02 June 2020
Ref: RH/Let/P1483i

Discharge of Conditions 14, 15, 16 and 18 pursuant to Application Reference A/74/18/OUT (Outline Planning Permission with all matters reserved, except access, for the demolition of existing outbuildings and the erection of 9No. two storey dwellings consisting of 2No. two bedroom dwellings, 3No. three bedroom dwellings and 4No. four bedroom dwellings) at The Laurels, Dappers Lane, Angmering, BN16 4EN.

Appendix A – Answers to Arun’s Drainage Engineer’s Queries in email dated 24 April 2020 (in red)

CLIENT	Oceanview Developments Ltd		
PROJECT	The Laurals Dappers Lane Angmering		
TITLE	Proposed Drainage Layout and Levels Plan		
DRAWN	M Pacifico	DATE	May 2020
ENGINEER	M Kemshall	CHECKED	
SCALE	1:250 @ A1, 1:500 @ A3	DWG. NO.	23260
		REV.	201 A

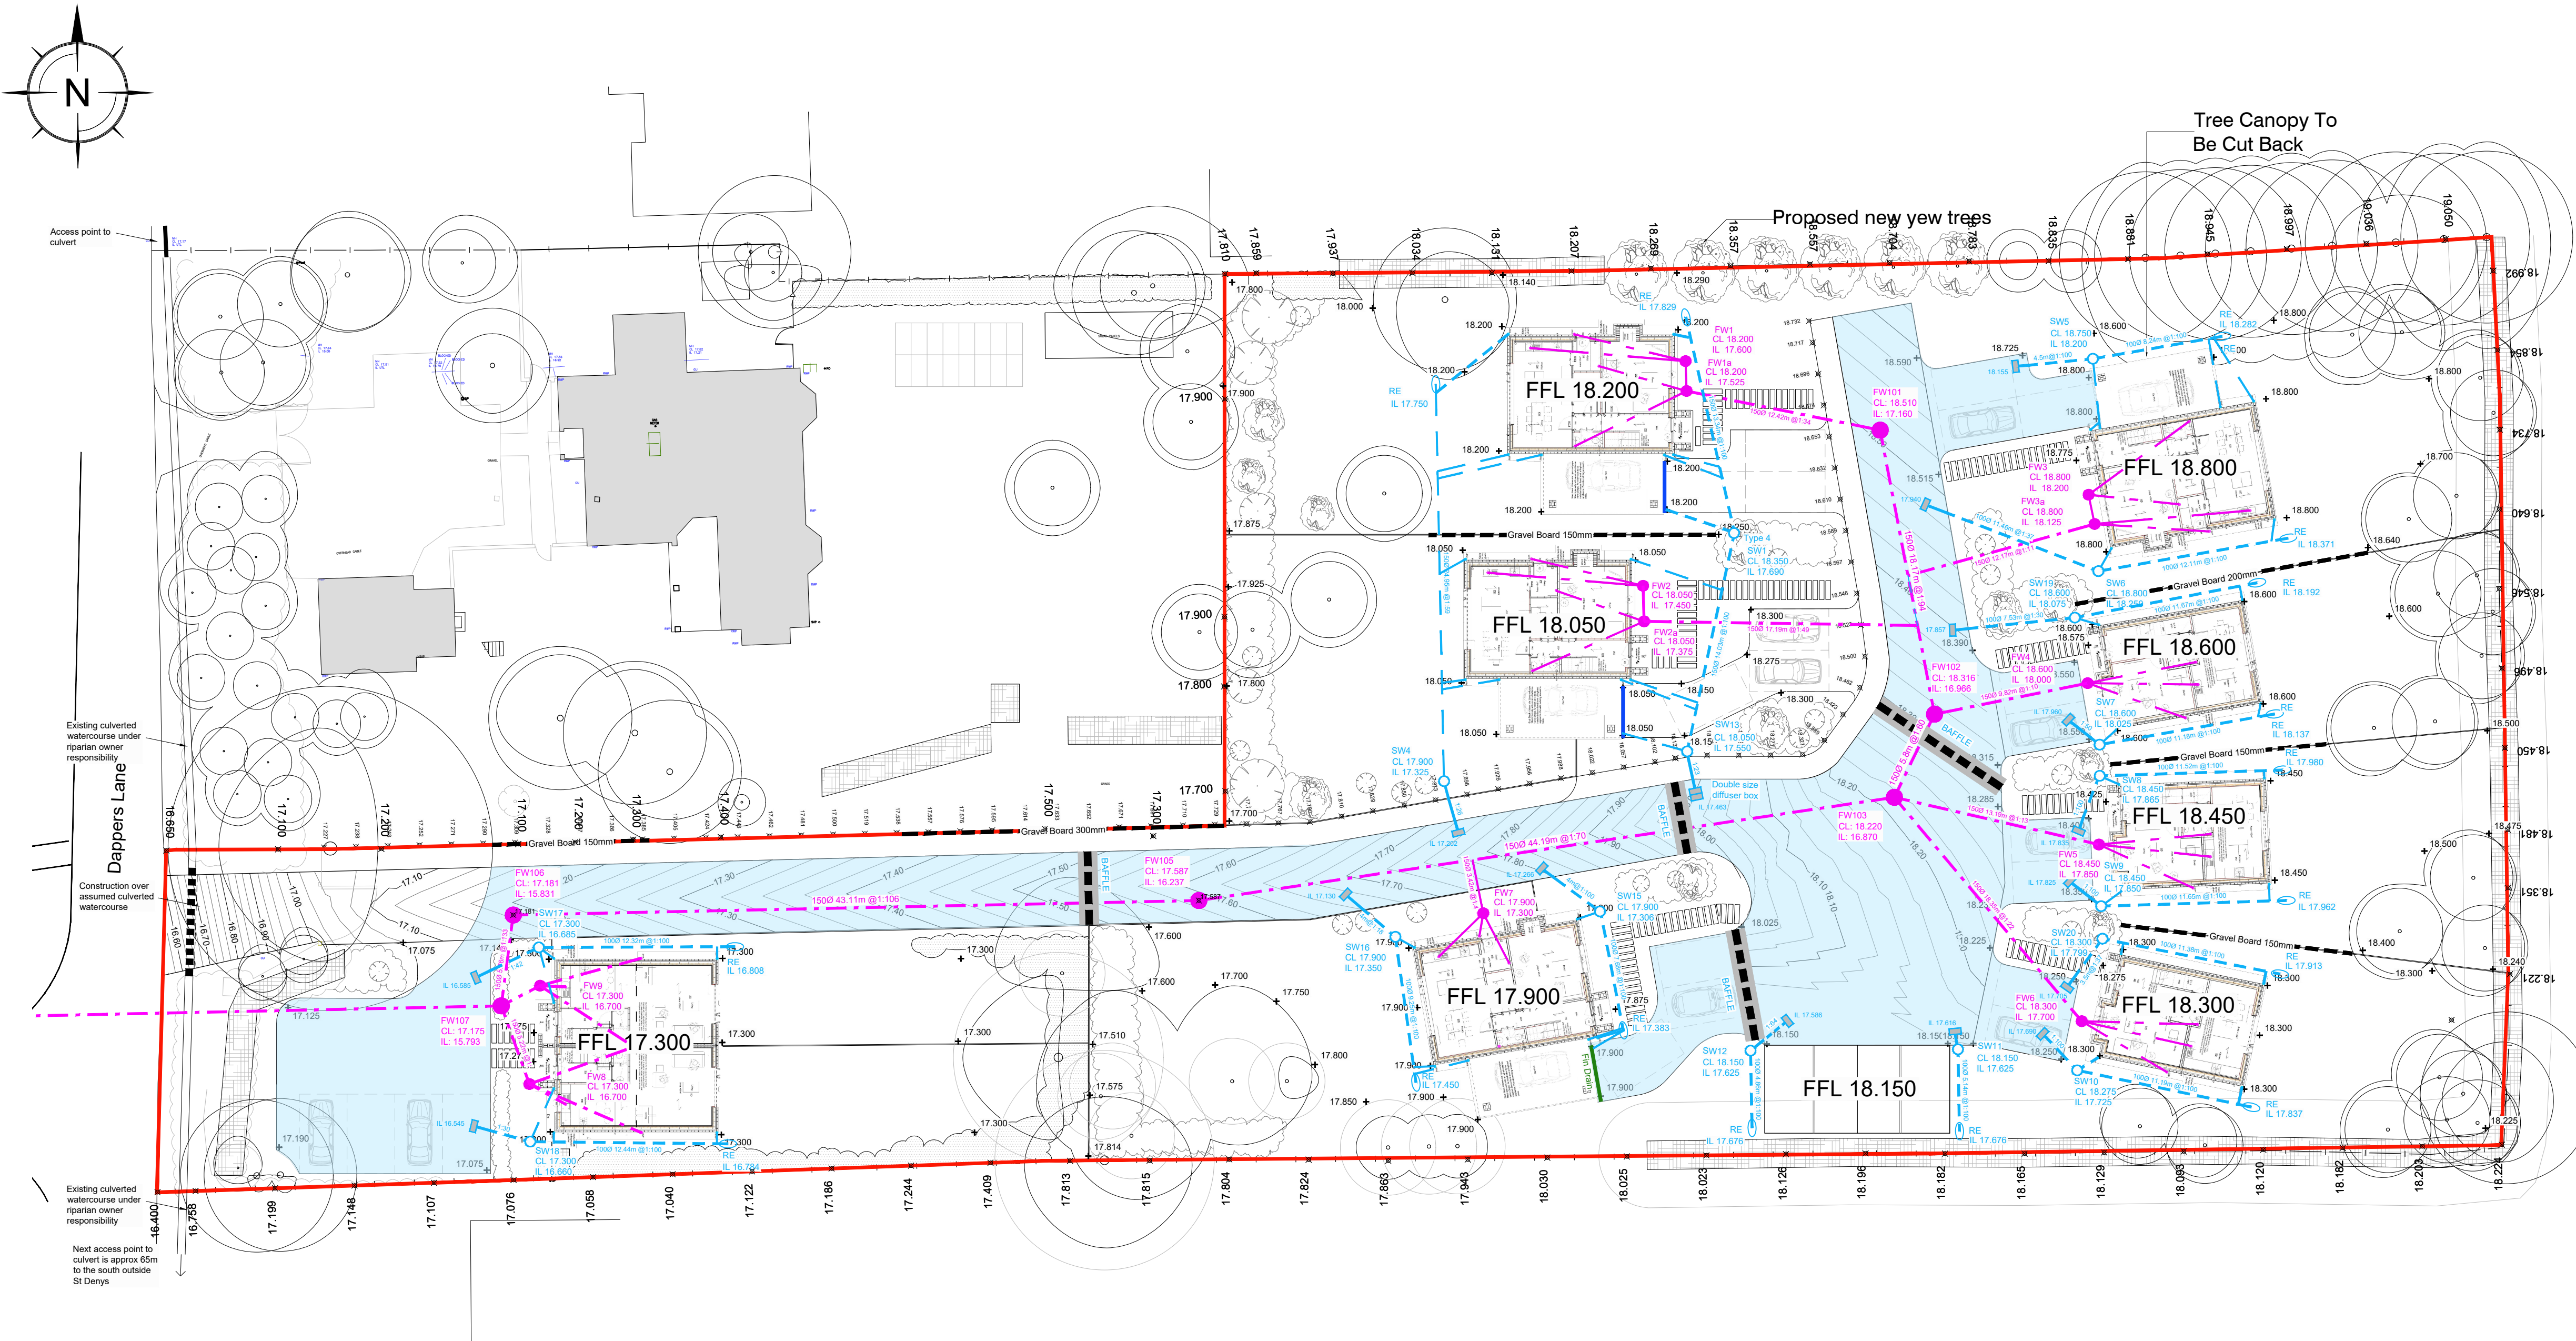
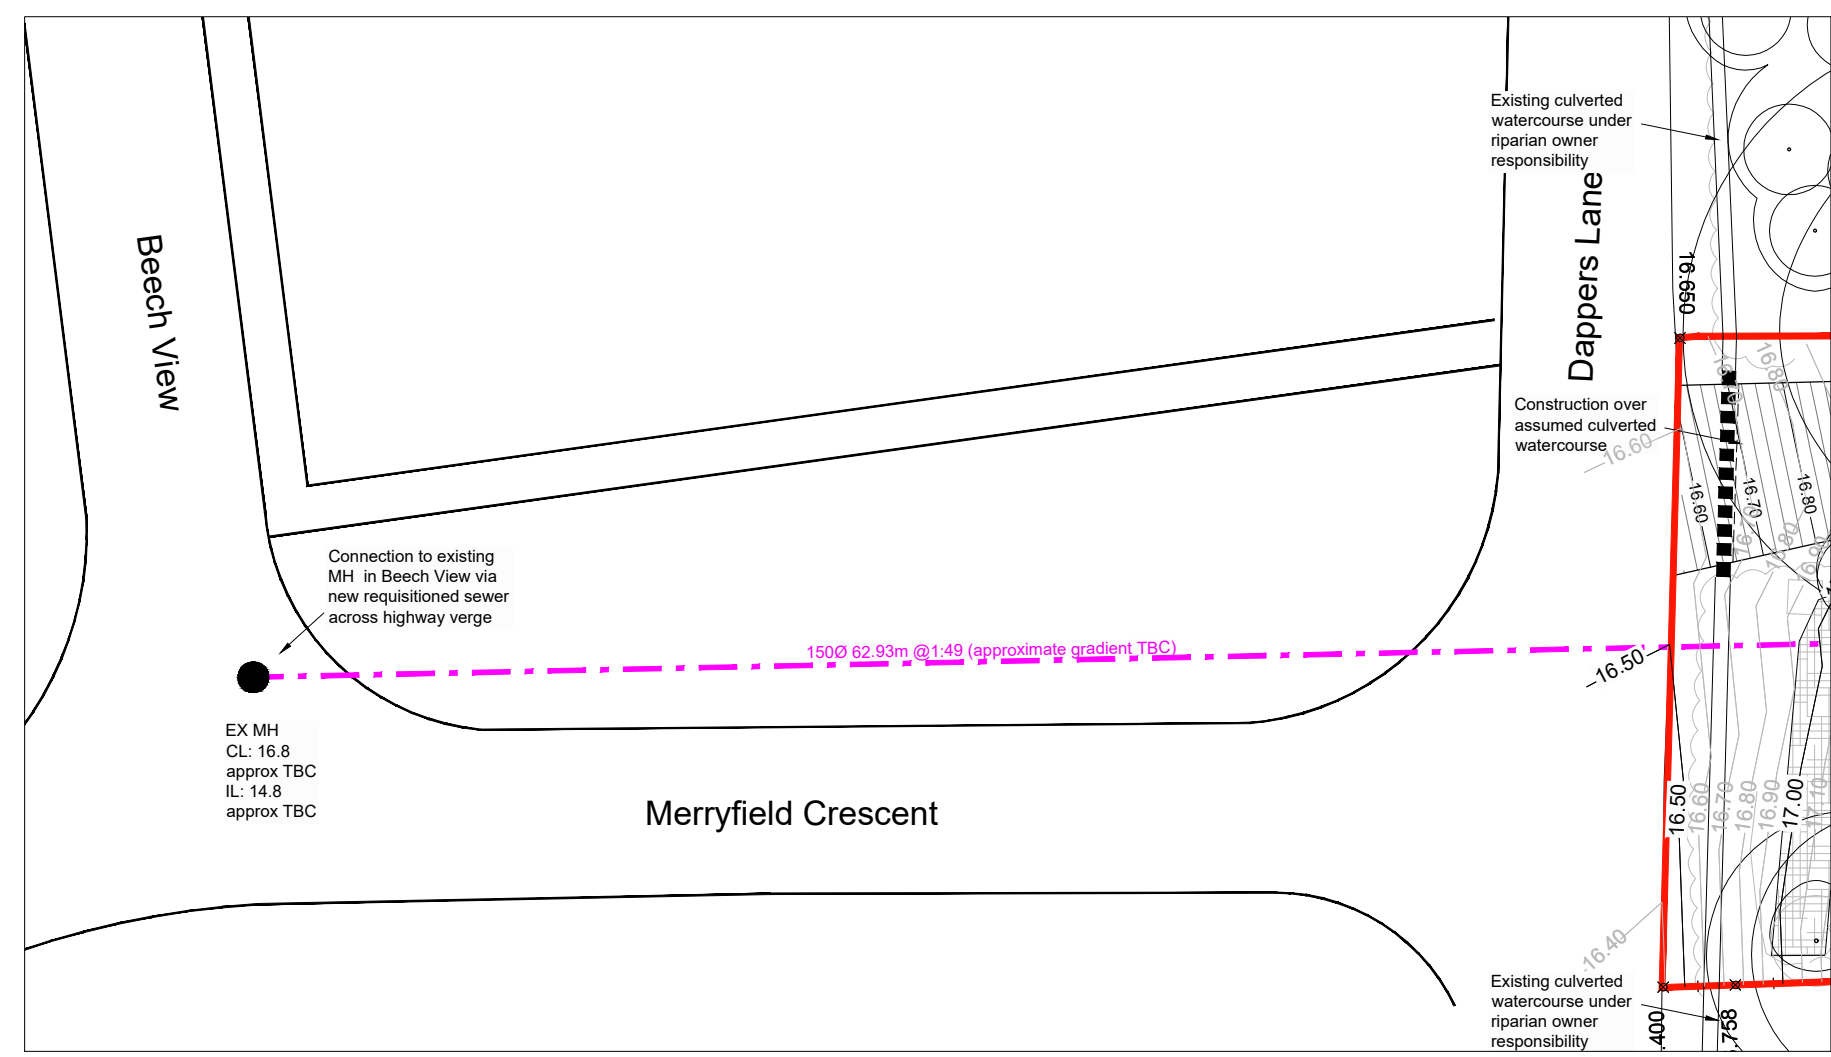
9. *Silt traps are required immediately upstream of all connections to the permeable pavement. Alter plan and provide construction detail (300mm sumps).*

10. Show RWP's on plan.

12. Drain serving garage block – reduce extent to which the drain extends into the permeable pavement.

13. Specify all pipe diameters and gradients.

17. Due to the varying finished levels of the permeable paving, I would like to see more baffles introduced.

This has been updated and reflected on drainage Drawing 201 with detail added to drawing 501.

These have now been included.

Updated on the latest drawings.

Now added to all pipework.

Additional baffles have been included as part of the new drainage catchments.
